CITY OF PORTLAND
 FIRE PREVENTION BUREAU
 380 Congress Street, Portland, Maine 04101
 fireprevention@portlandmaine.gov
 (207) 874-8400

NOTICE OF VIOLATION AND ORDER TO CORRECT

Responsible Party 1: JOHNSON JEFFREY S 58 CODMAN ST PORTLAND, ME 04103		
Location 54 CODMAN ST	CBL 128 A009001	Inspection Date 8/9/2017
Inspector Brad James	Inspection Type FP Routine Inspection	Status Failed

(2) PLAN -3RD FLOOR

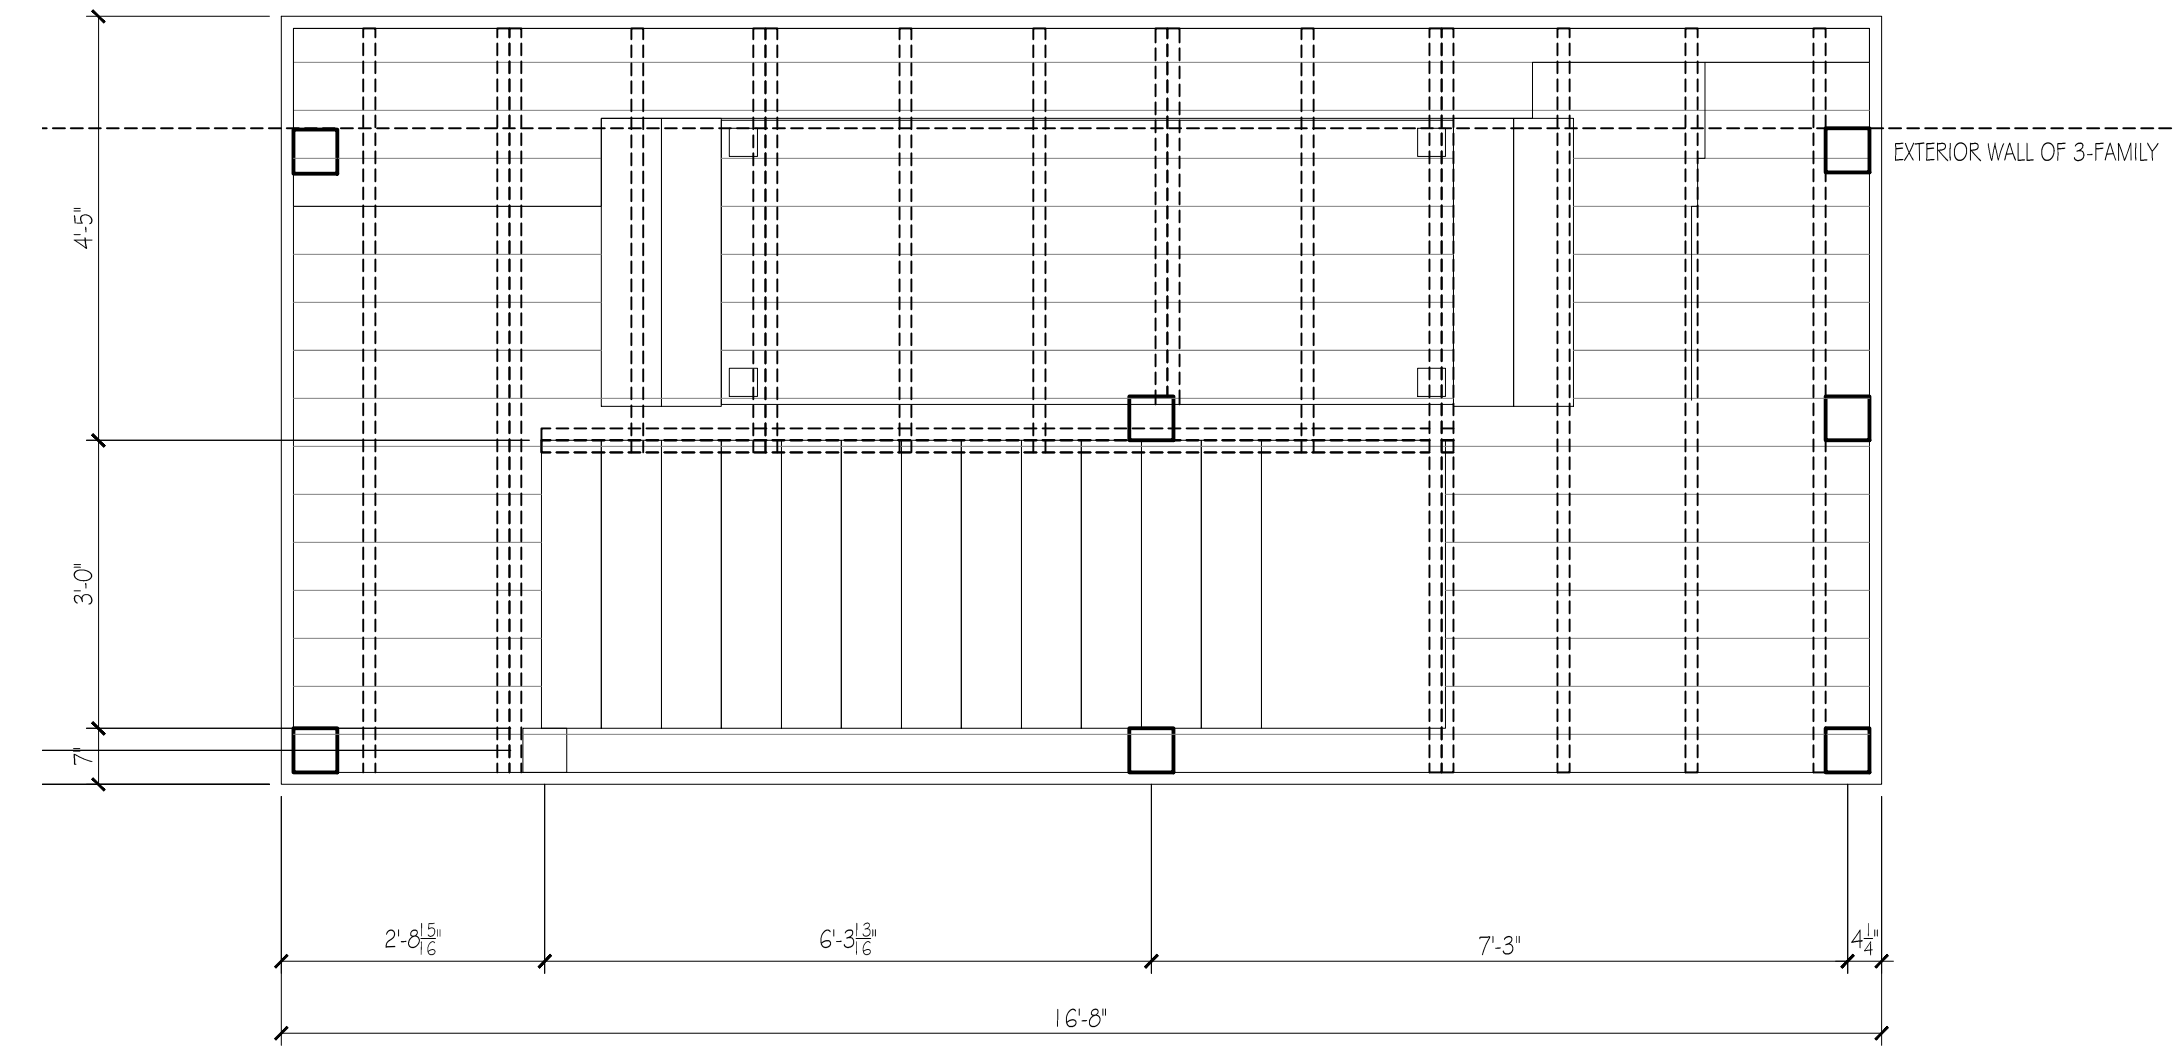
Violation	Proposed Date of Completion
NFPA 101- 7.2.1.8.1 DOORS SHALL BE SELF-CLOSING & SELF-LATCHING; A door leaf normally required to be kept closed shall not be secured in the open position at any time and shall be self-closing or automatic-closing in accordance with 7.2.1.8.2, unless otherwise specified by 7.2.1.8.3. 2ND FLOOR REAR FIRE DOOR NEEDS ADJUSTMENT TO MEET CODE. ALSO 3RD FLOOR DOOR IN THE FRONT STAIRWELL ON THE 2ND FLOOR LANDING NEEDS ADJUSTMENT TO MEET THE CODE.	
NFPA 101- 7.1.3.2.1 60-MIN FIRE DOOR ASSEMBLIES REQ; The separation shall have a minimum 1-hour fire resistance rating where the exit connects three or fewer stories. BASEMENT DOOR REAR STAIRWELL NEEDS TO BE FIRE RATED. Owner may want to block off opening with fire rated material on both sides.	
NFPA 1- 10.1.1 STRUCTURE NEEDS REPAIR; Every new and existing building or structure shall be constructed, arranged, equipped, maintained, and operated in accordance with this code so as to provide a reasonable level of life safety, property protection, and public welfare from the actual and potential hazards created by fire, explosion, and other hazardous conditions. REAR EXTERIOR DECK NEEDS REPAIR OF FLOOR BOARDS ON 3RD LEVEL.
